Transport
for NSW

TfNSW Reference: SYD21/00574/04

DPIE Reference: SSD-18204994

**EXHIBITION OF EIS - EXHIBITION OF EIS - SNACK BRANDS MANUFACTURING
FACILITY - 14 & 2 DISTRIBUTION DRIVE, ORCHARD HILLS**

ENTRY (FOR AV REAR LOADING)

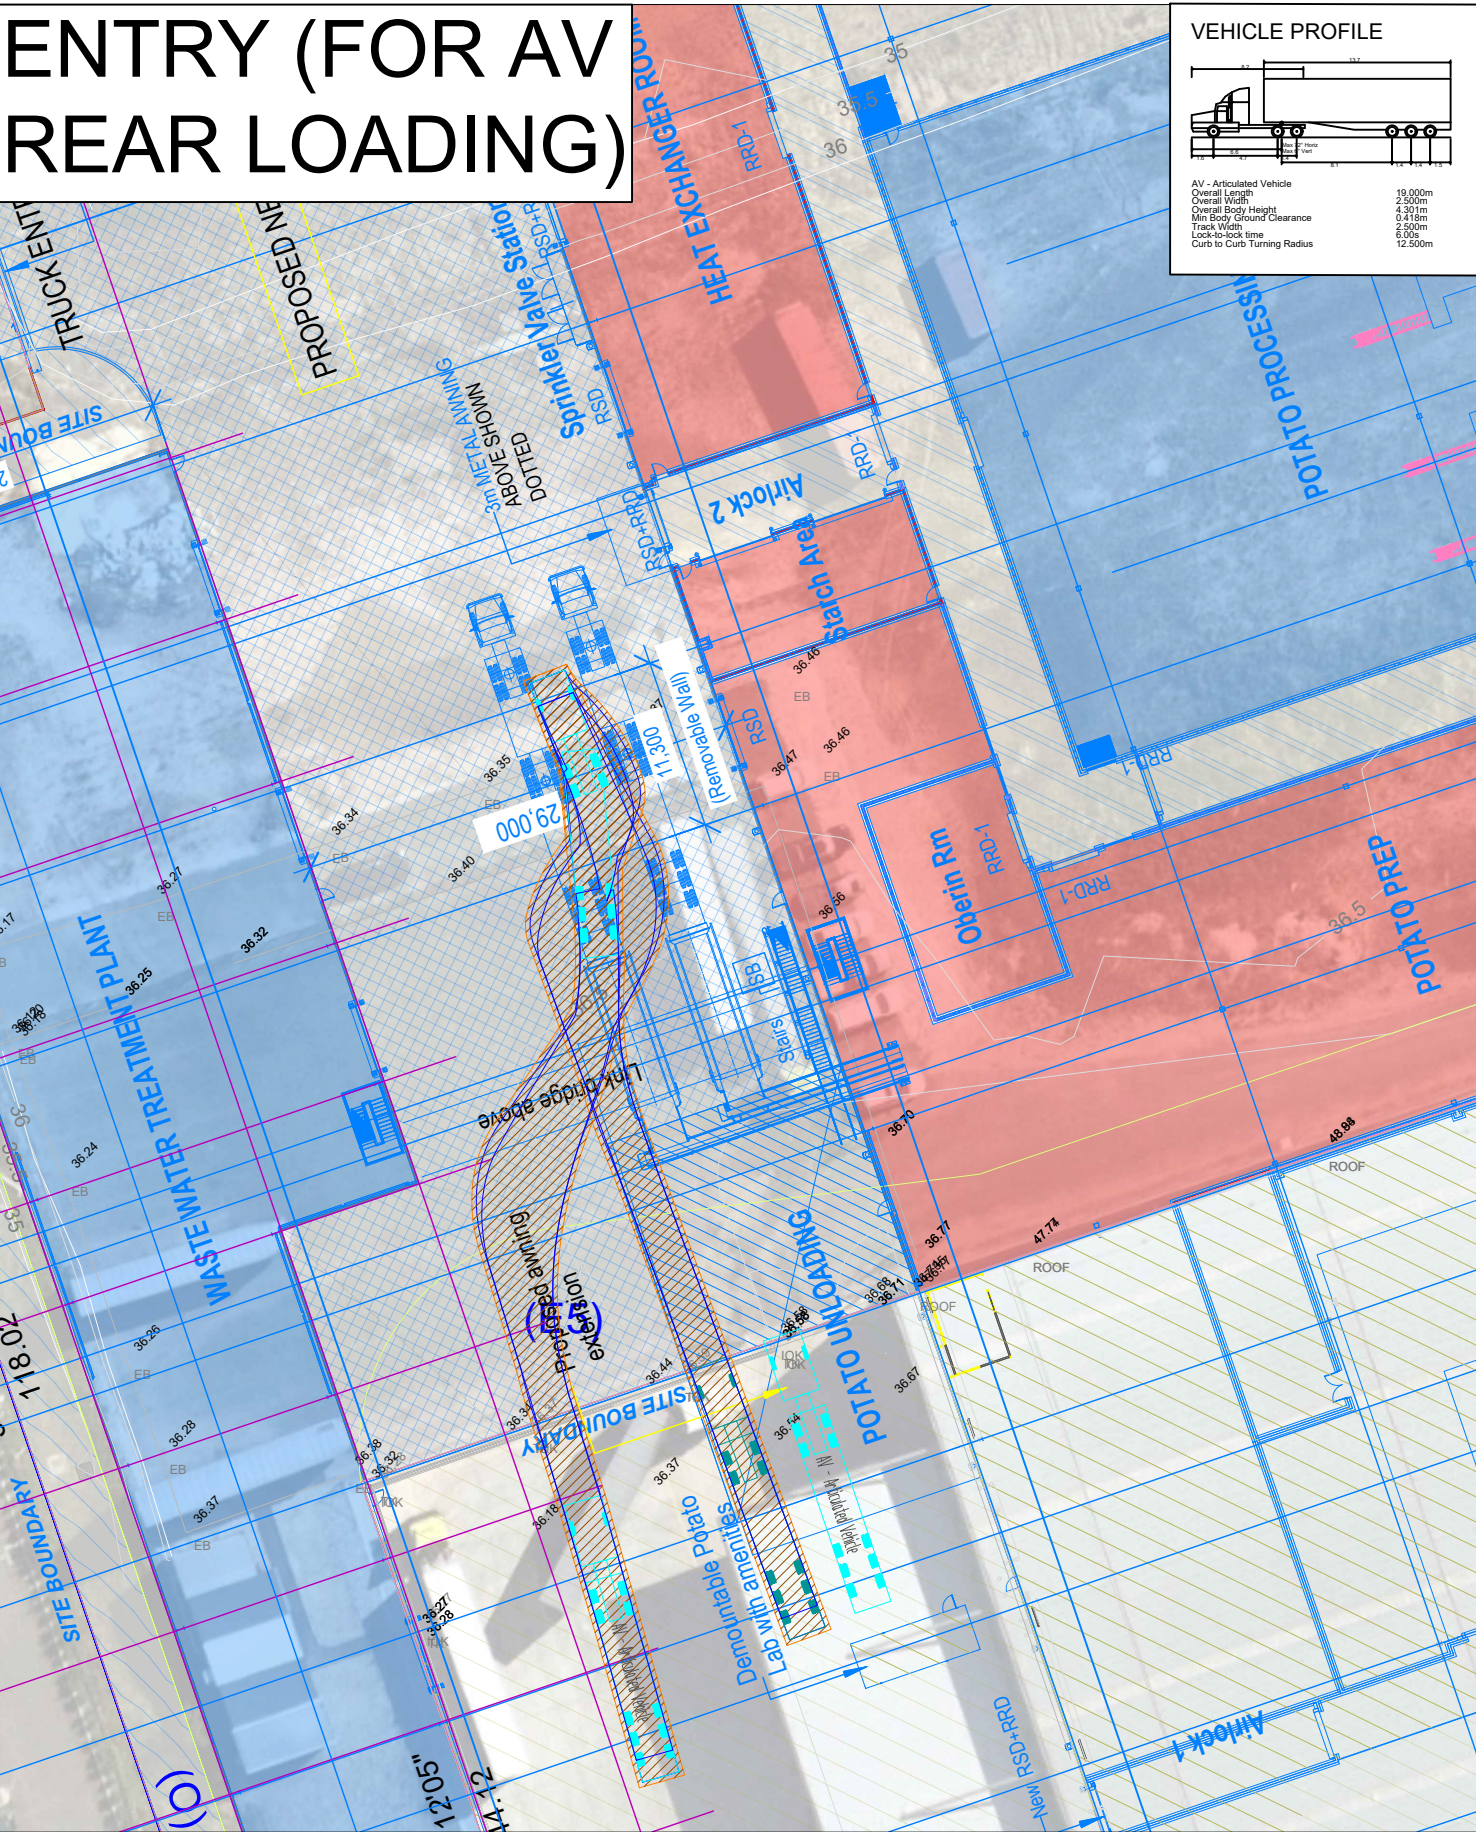
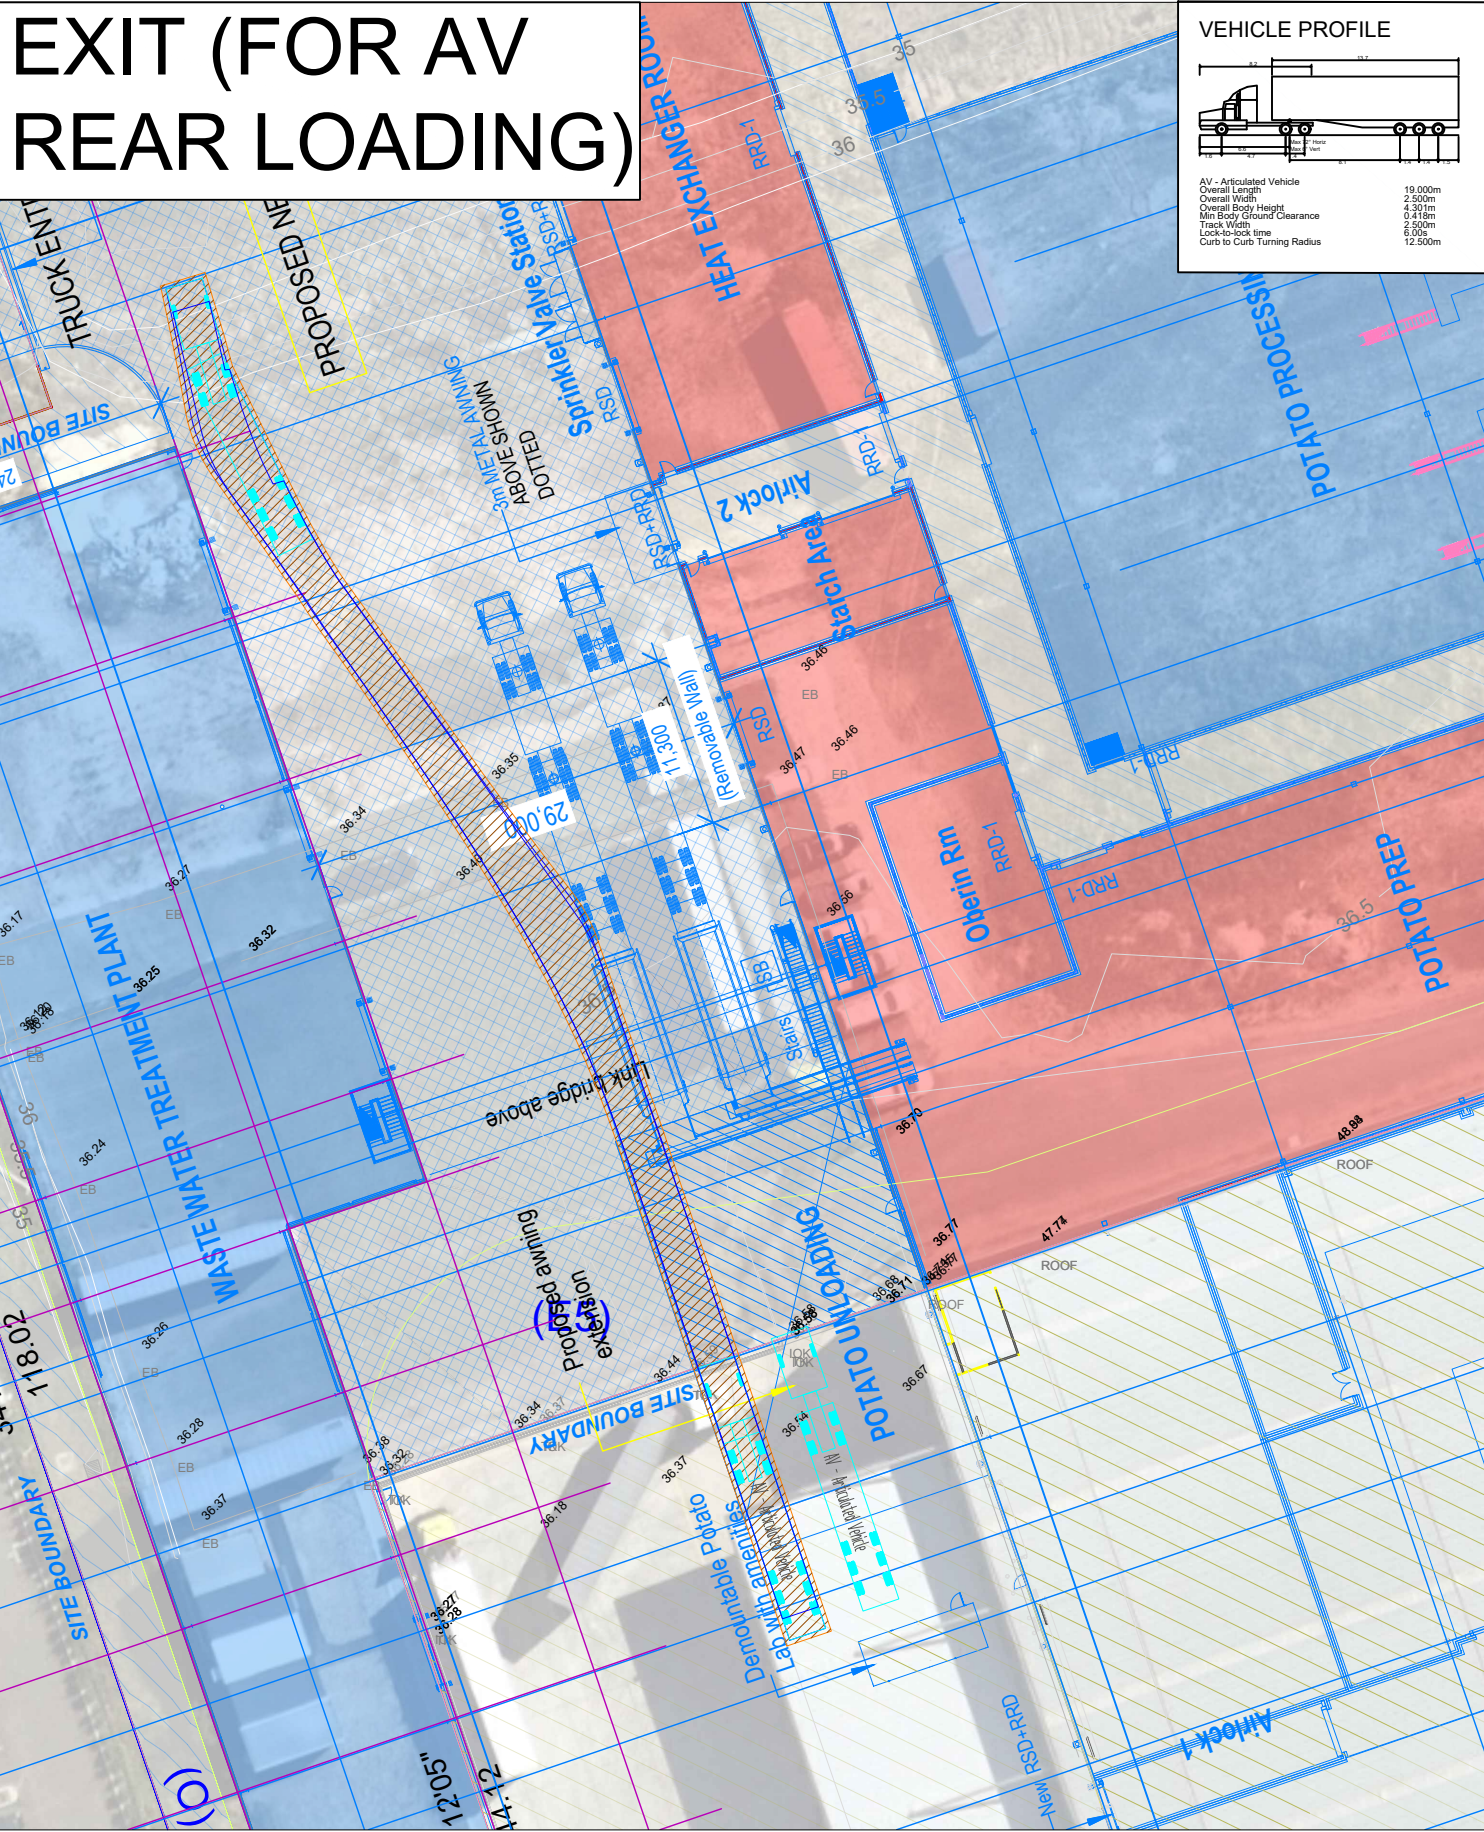
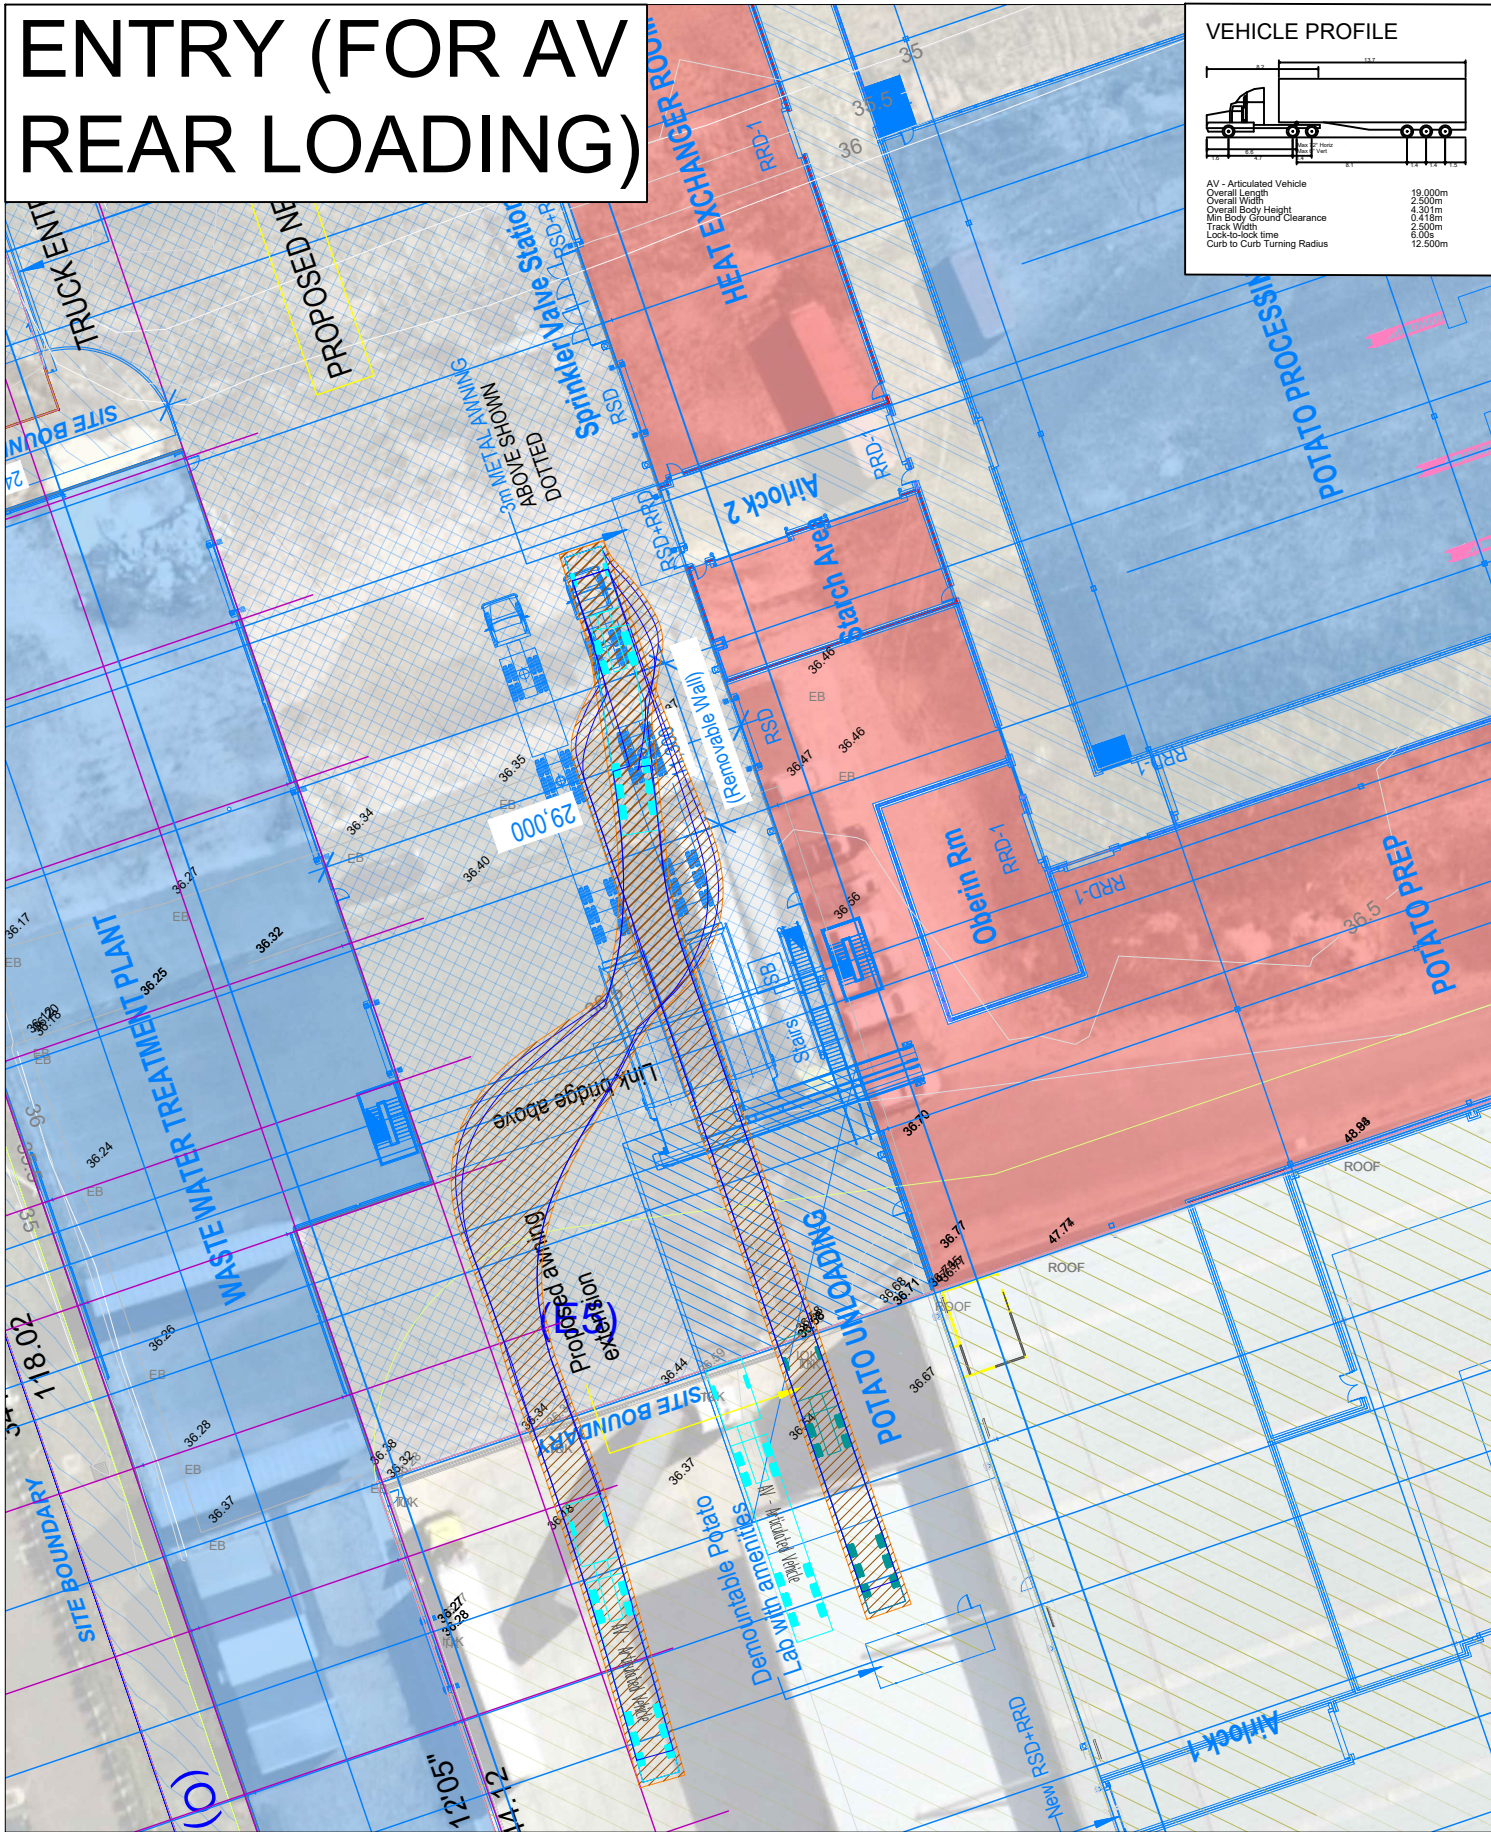
The TA has acknowledged two RSDs where B-doubles will be need to be reversed to unload from the rear. As the rear trailer is in the way, the front trailer (or A-trailer) of a B-double is typically unloaded by de-coupling the trailers, or jack-knifing the combination.

The TA needs to clarify whether a de-coupling area is required so that both the 'A' and 'B' trailers can be unloaded from the rear for the two RSDs which require B-double reverse movements.
